Subject: AW/159/21/HH - Objection to Planning Application

I am writing to comment upon the planning application AW/159/21/HH which relates to the property neighbouring my own.

2 Loft  
1 : 100

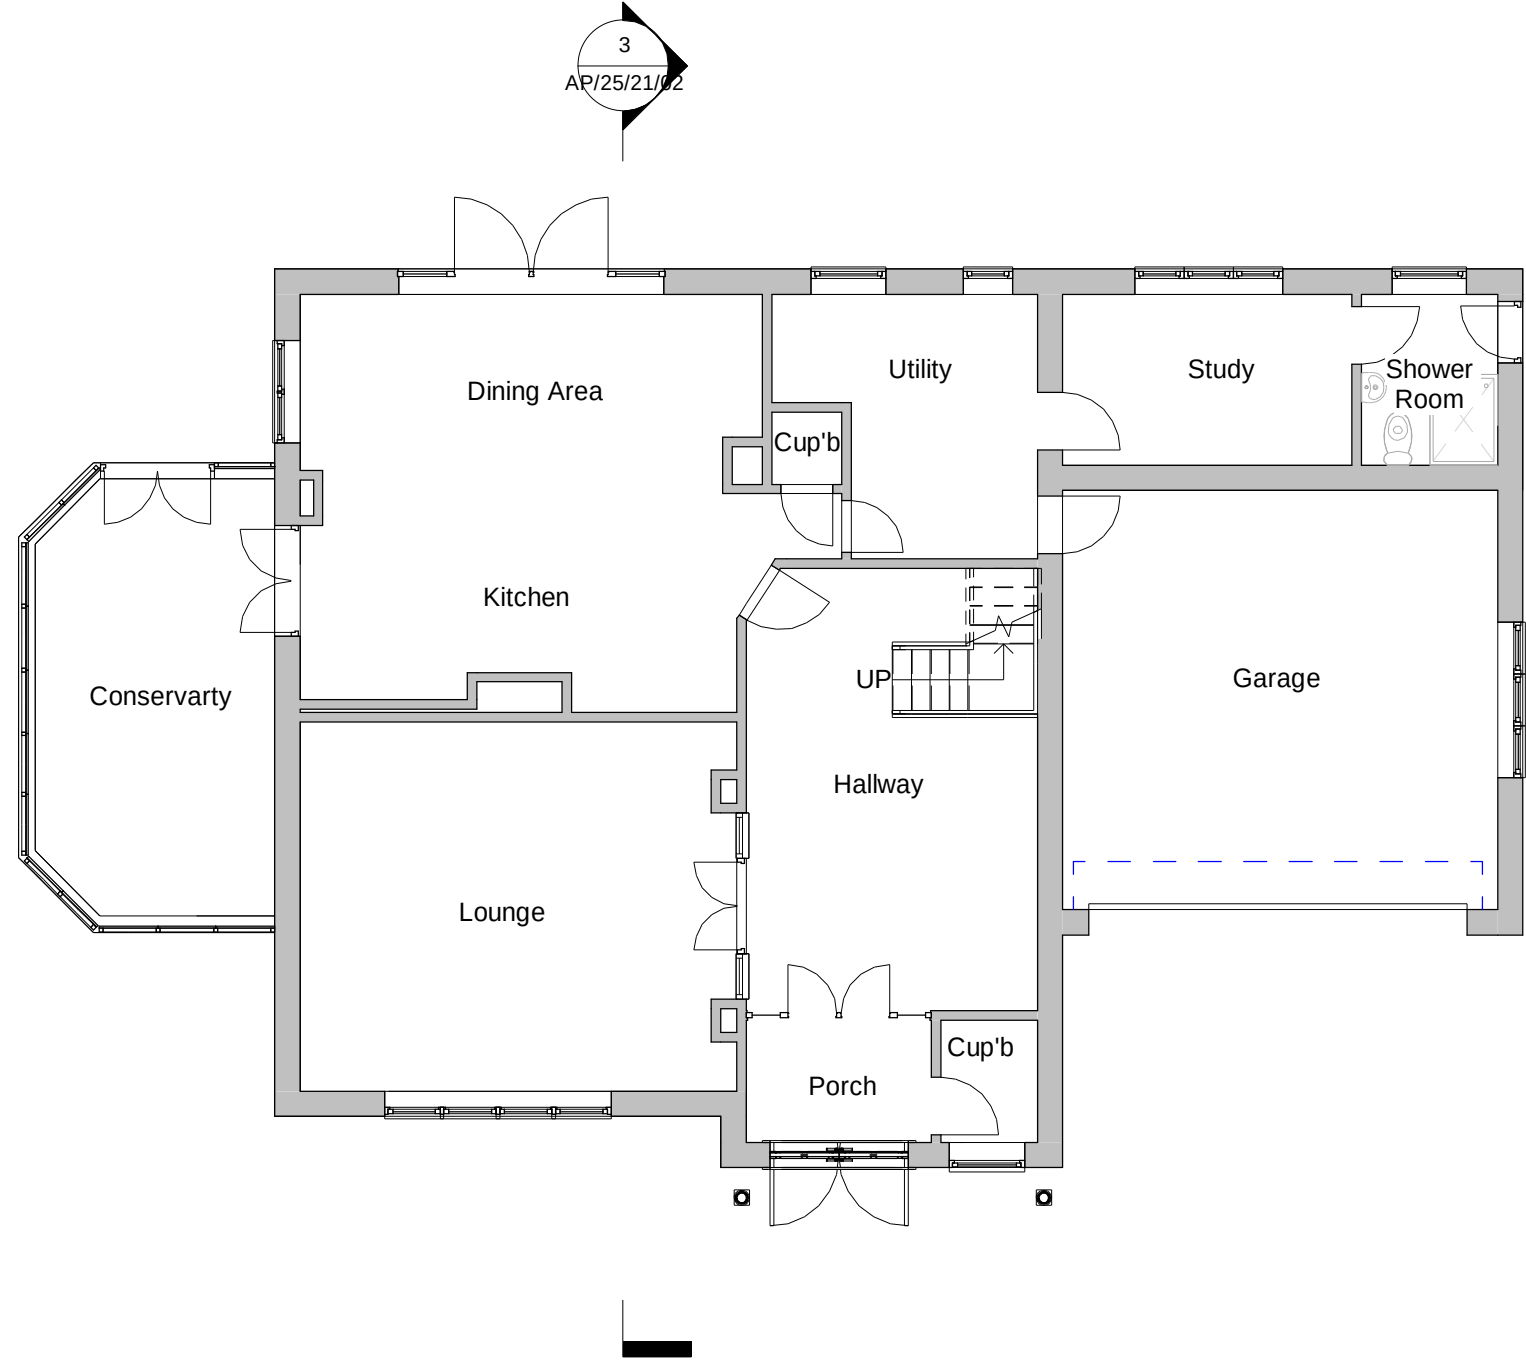
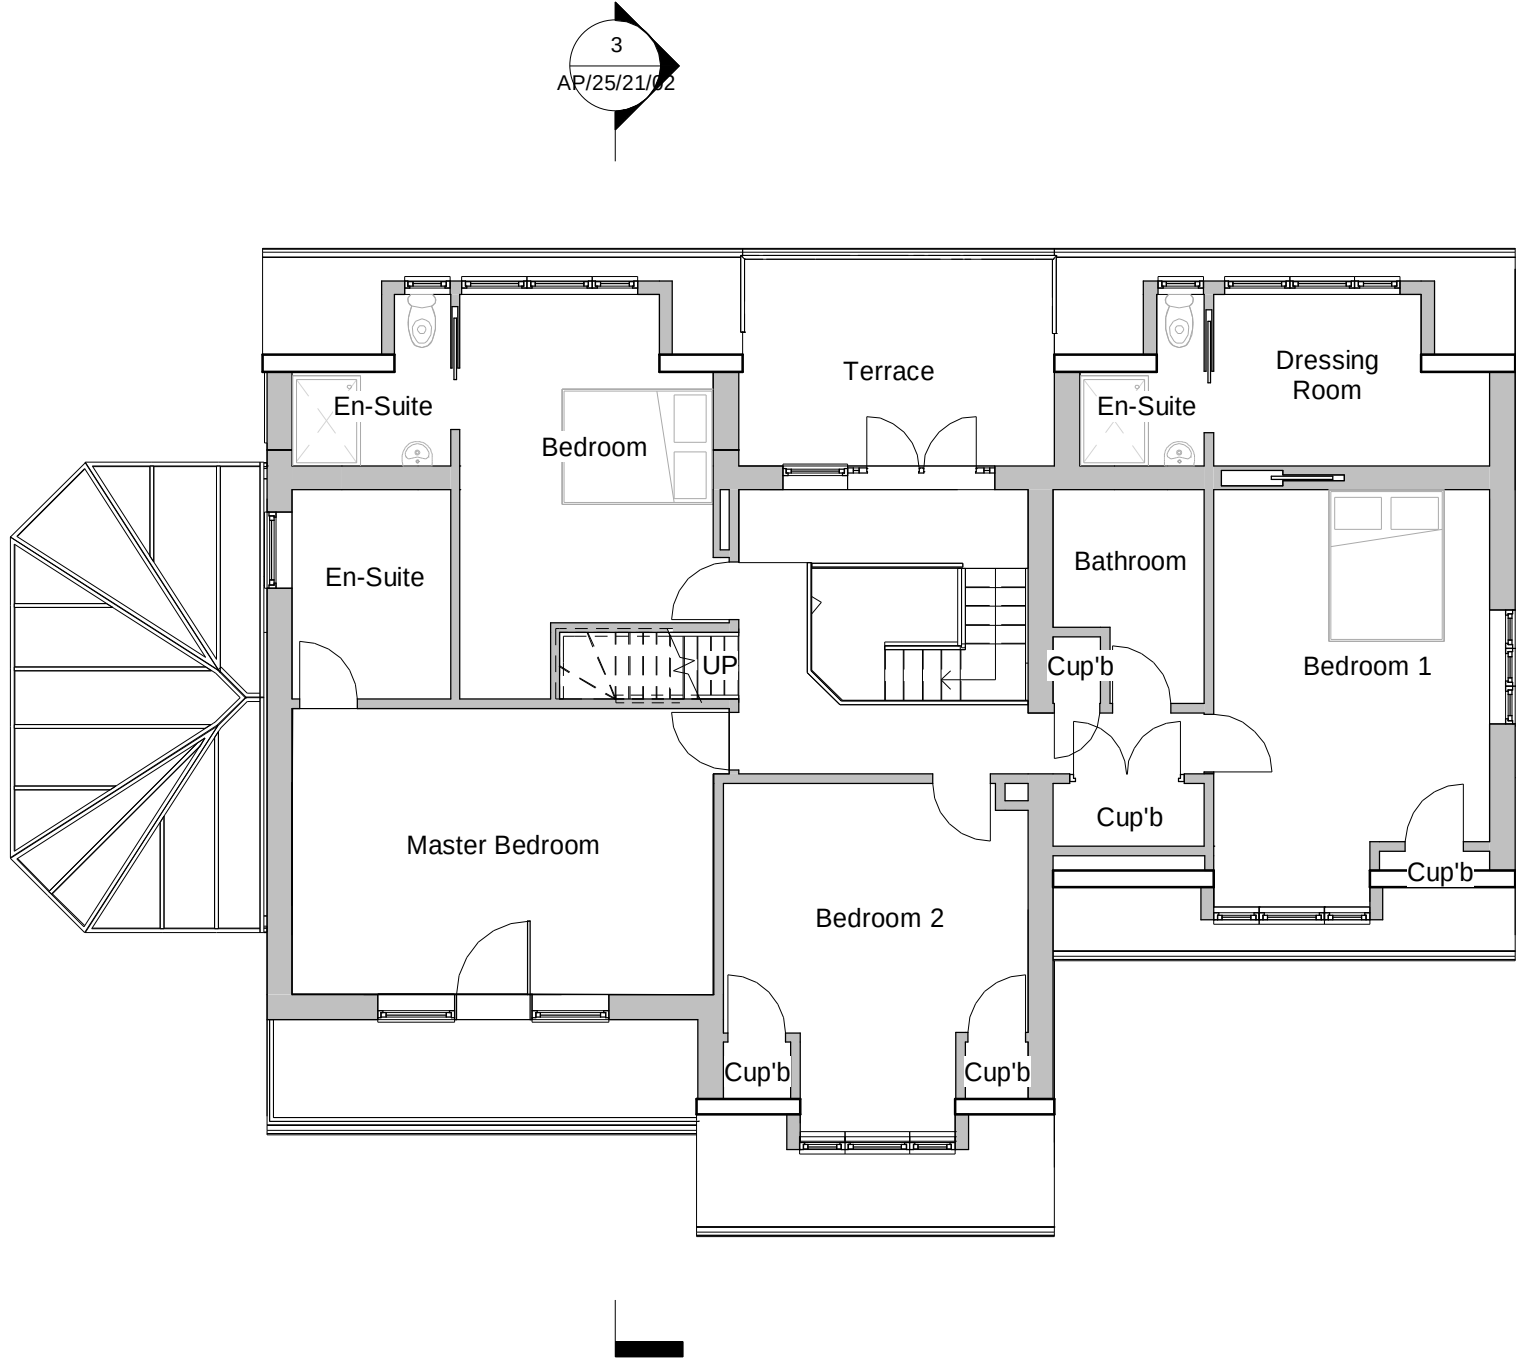
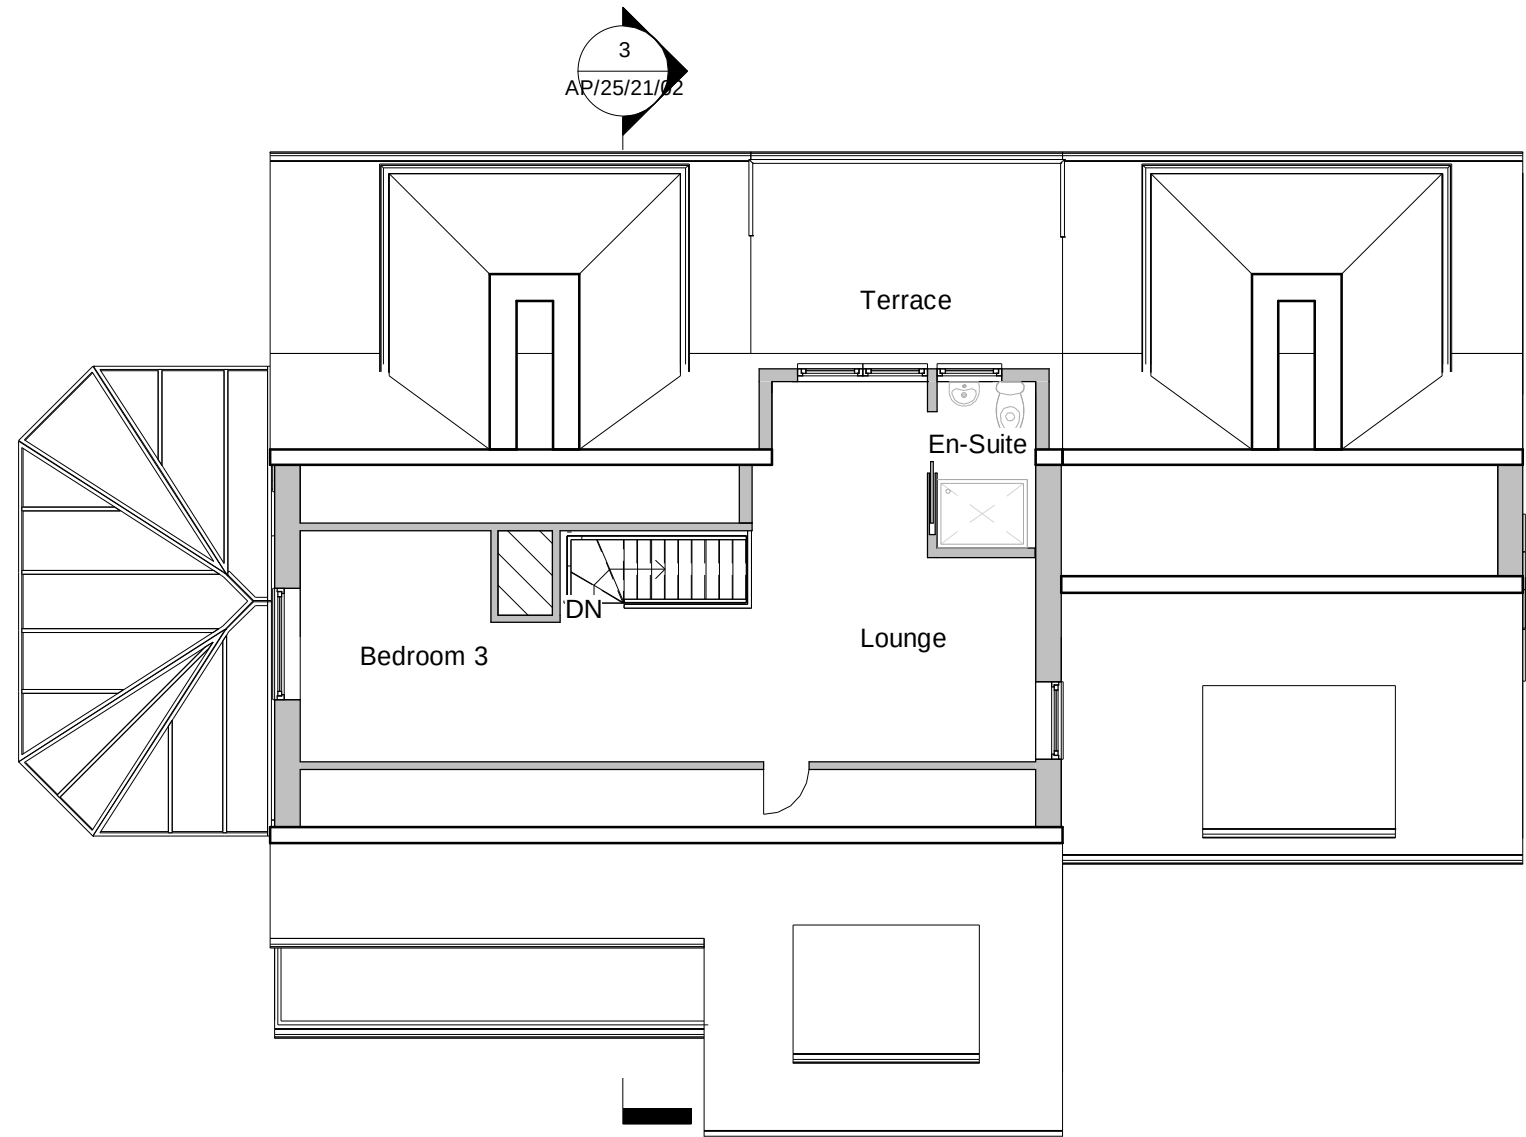
roof pitch around the first floor dormer extension leading up to a flat roof across most of the dormer. This does not fit in with the plan of the loft (Plan 2) which shows a very small flat roof on the two dormers; nor with the two side elevations (plans 7 & 8) which show a significant pitched roof over both dormers. There is also apparent contradiction with the rear elevation drawings (Plan 5) which show no flat roof on the first floor dormers at all.

Turning to the second floor drawings, the floor plan shown on Plan2 (Loft) shows a relatively small increase in the floorspace; but the size of the dormer shown on both the side elevation (plan 8) and on the rear elevation (plan 5), both appear to be significantly larger.

3 Section A-A  
1 : 100

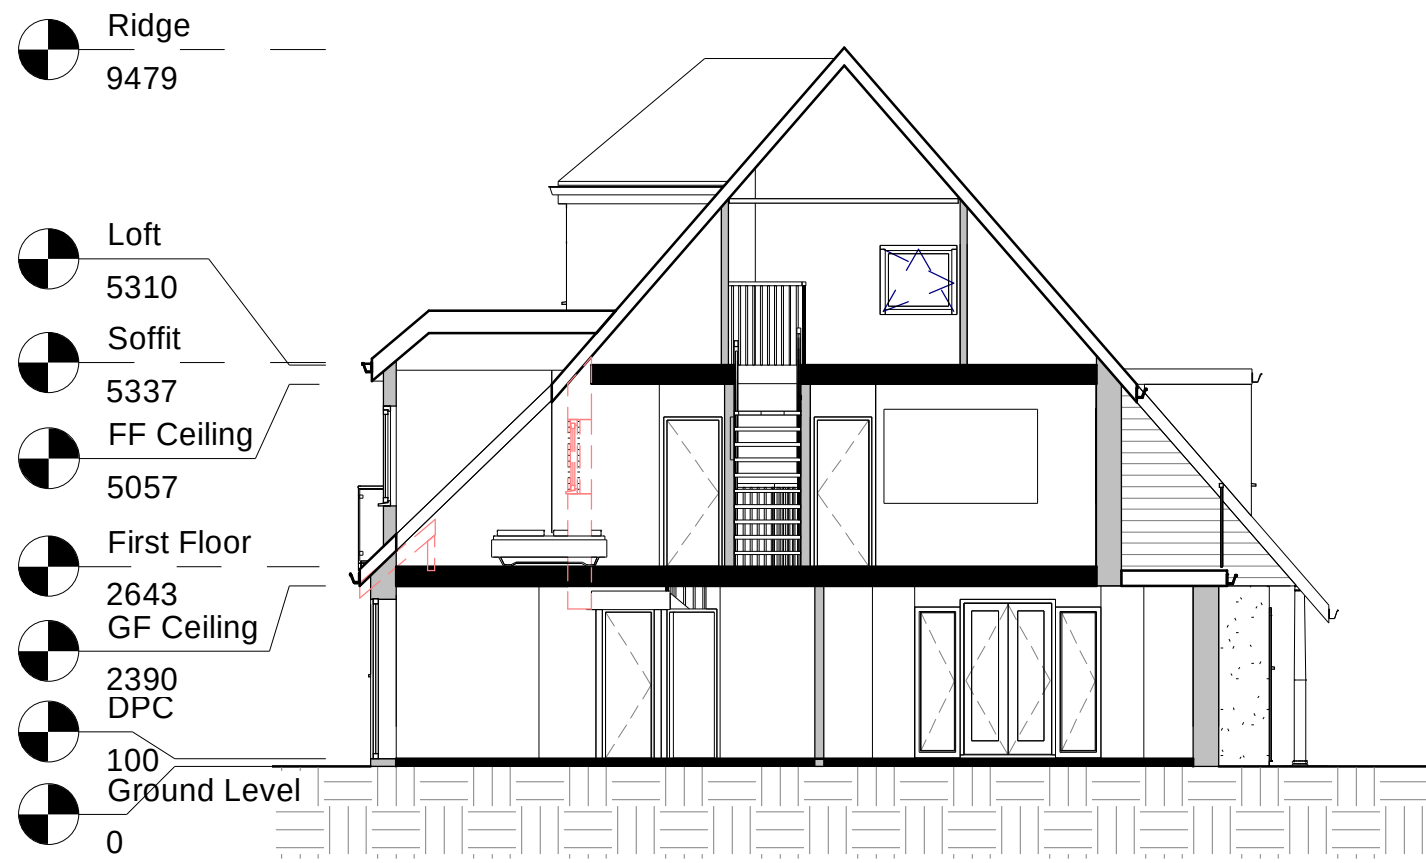
I also draw to your attention that the drawings do not appear to be consistent throughout. In particular I would draw attention to section A – A (Plan 3) which appears to show a very shallow
